### Application for a Non-Material Amendment Following a Grant of Planning Permission

'Householder application for first floor loft space extension, replacement of existing flat roof and existing roof finishes to existing garage wing.'

Our proposed amendments are minor alterations to a previously agreed application and our proposal does not increase the footprint nor the overall height of our property that sits on the boundary of Hardwick and Whitchurch Parish Councils - both of whom have previously approved our application.

APPROVED PLANNING OF ISOMETRIC VIEW LOOKING SOUTH WEST

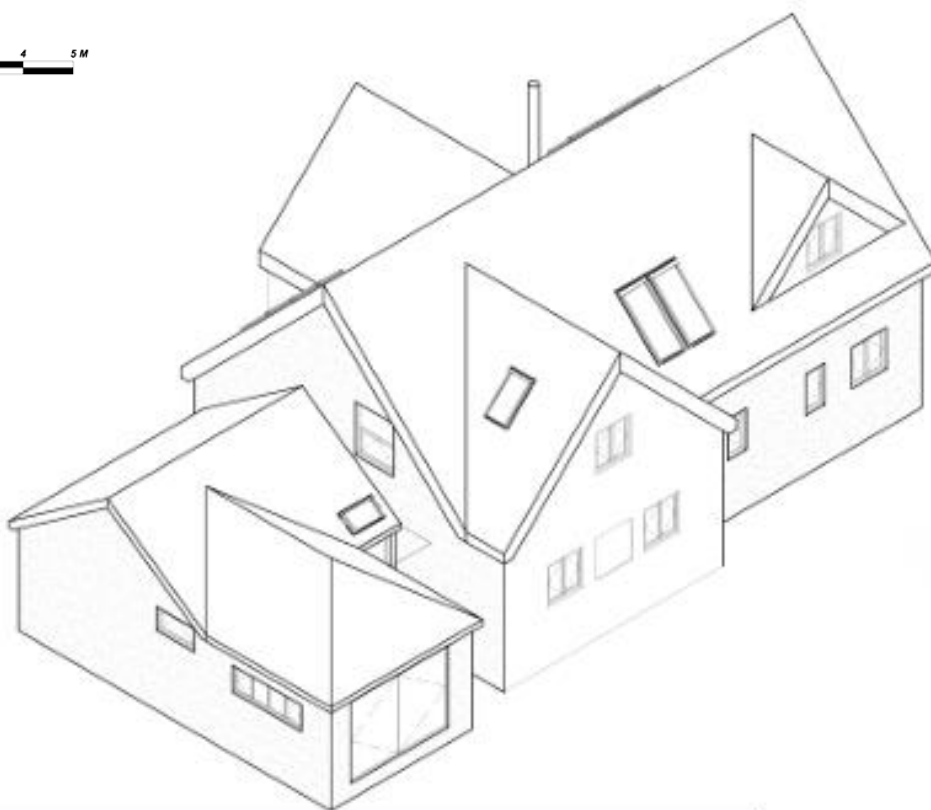
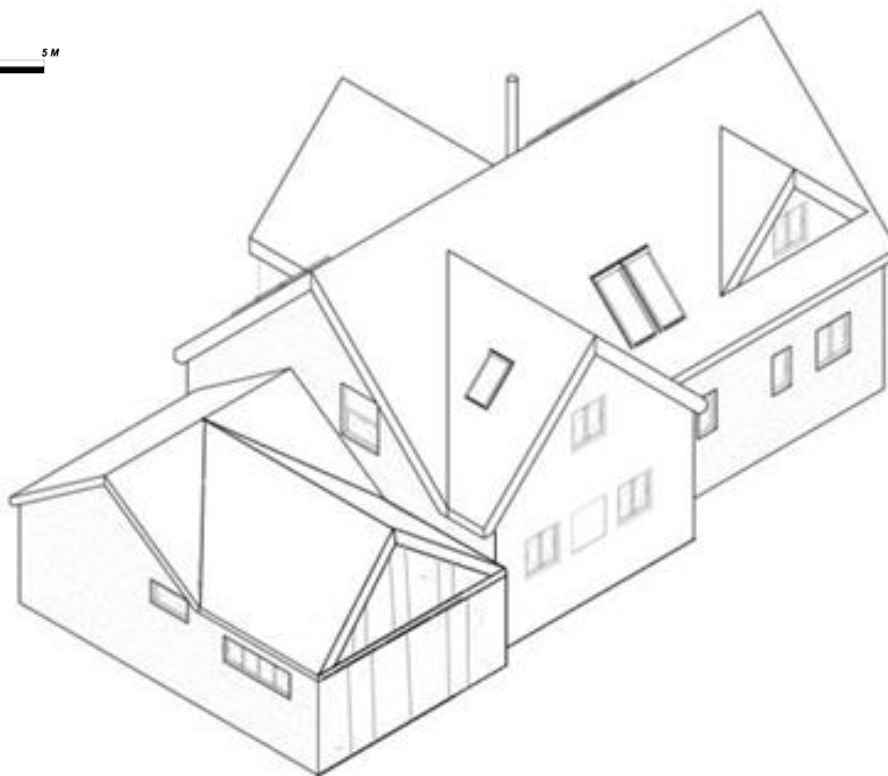
Briefly, the NMA is to change the planned structure from a storage entrance into a main entrance - utilising what would be a storage area into a reception room/hall and front entrance on the eastern side of the property.

This alteration would also necessitate changing the roofing over the front entrance to the property from a hip roof - as approved, to a traditional arch/gable entrance. The proposed change in roof style will not add any increased height to the overall height of the main property.
